Response to Issues – Department of Planning and Environment

80-88 Regent Street, Redfern – SSD 7080

Issues raised by DP&E in February 2017

04. Revised DA non-compliant tower and podium setbacks

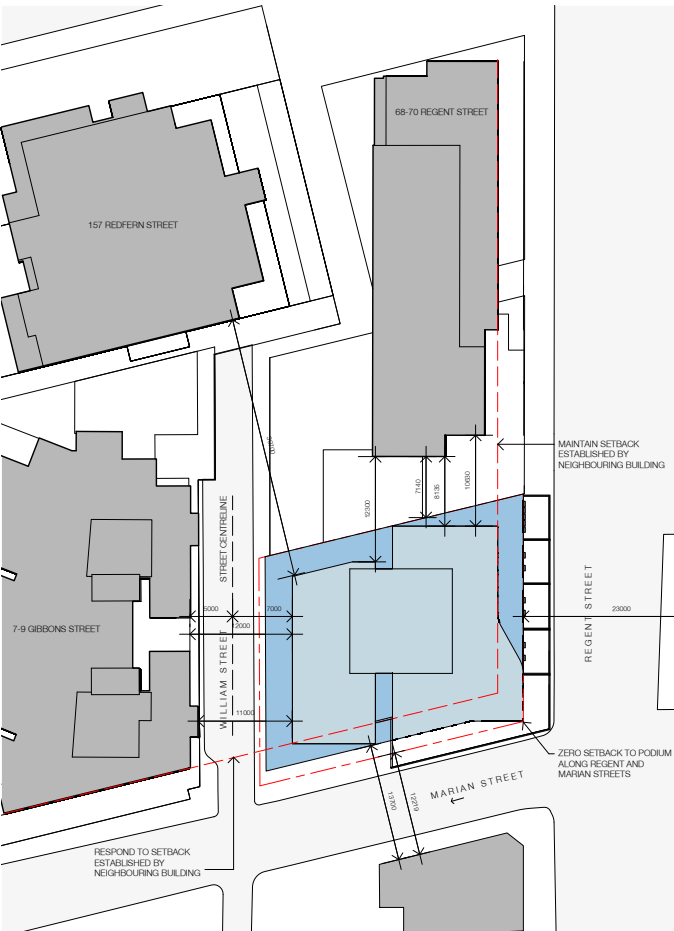
Setbacks, Building Separation and Design Response	10. Additional justification is required to demonstrate how the proposed built form and setbacks have considered, addressed and minimised impacts on adjacent residential amenity, including privacy, views, outlook, ventilation and solar access, and specifically, how the proposed built form and setbacks do not increase amenity impacts beyond those envisaged by the planning controls for the site.	Setbacks have been amended. Setbacks minimise amenity impacts.	Refer to Section 4.2.2, 4.3, 4.8 and Attachment 1

1 North Elevation
1: 200@A1

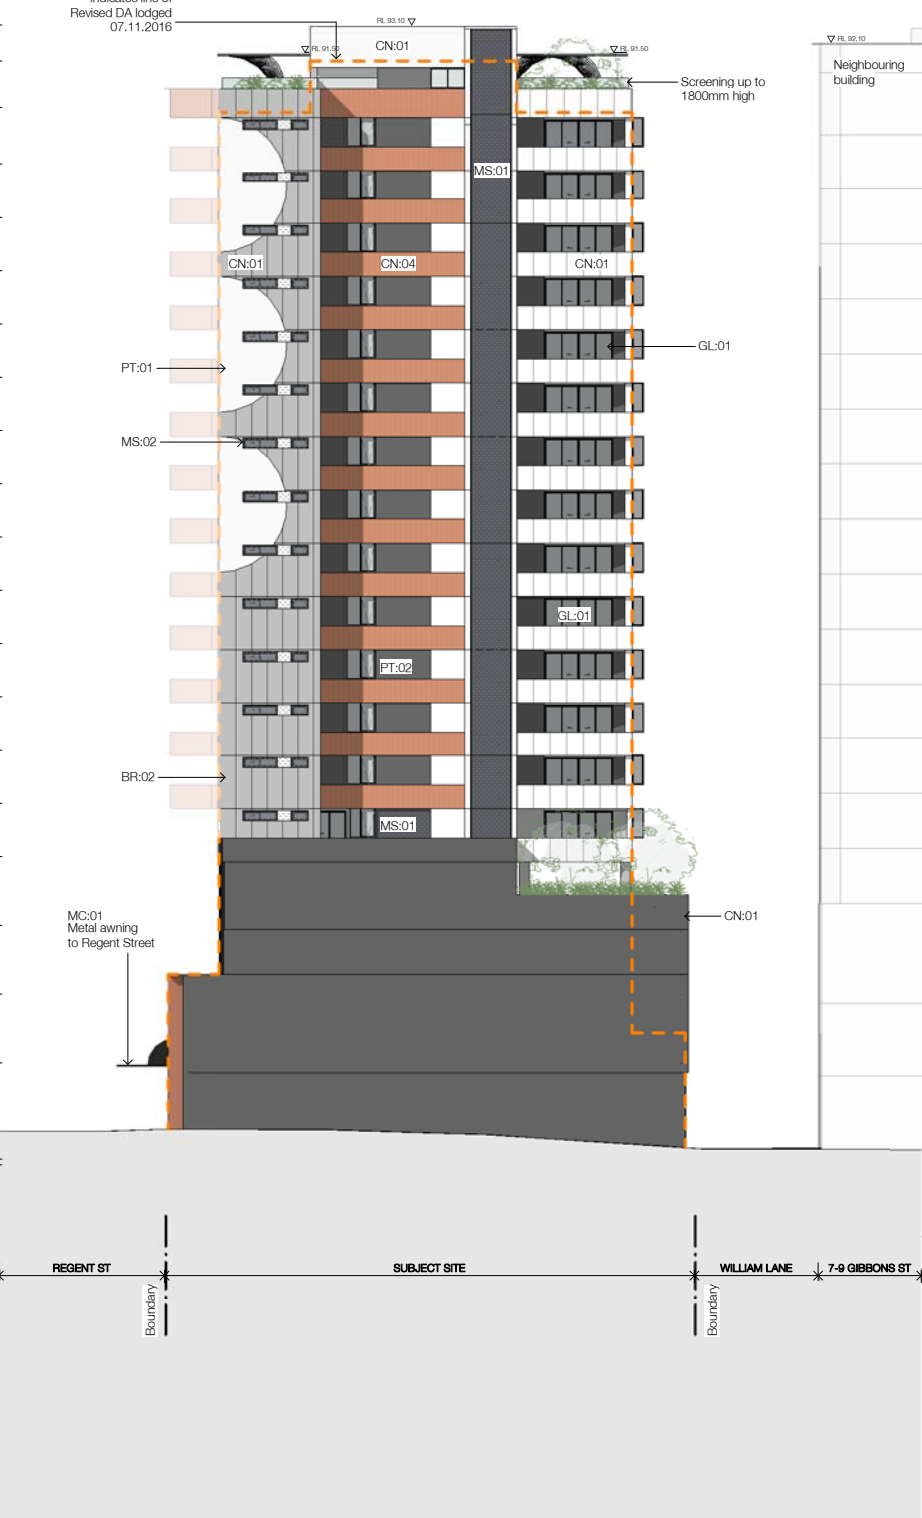
Matter	Particulars of Issues	Response	Location in Report
Setbacks, building separation and design response	<i>The reduced setbacks on all boundaries from those required by SEPP (SSP) and SEPP No 65 results in excessive bulk inconsistent with the intended built form for the area and with the predominant and proposed built form of adjacent sites.</i>	The increased setback to the northern boundary and setbacks to the west and south are in keeping with predominant building separations within the proposal will not have undue amenity impacts in terms of overshadowing, privacy, or view loss because of variations to building setbacks.	Refer to Section 4.2.2 and 4.3
	<i>The reduced setbacks and building separations result in impacts on surrounding properties (privacy, solar access, views and outlook) beyond those impacts envisaged by the planning controls for the site.</i>	The northern setback has been increased	Refer to Section 4.3 and 4.8
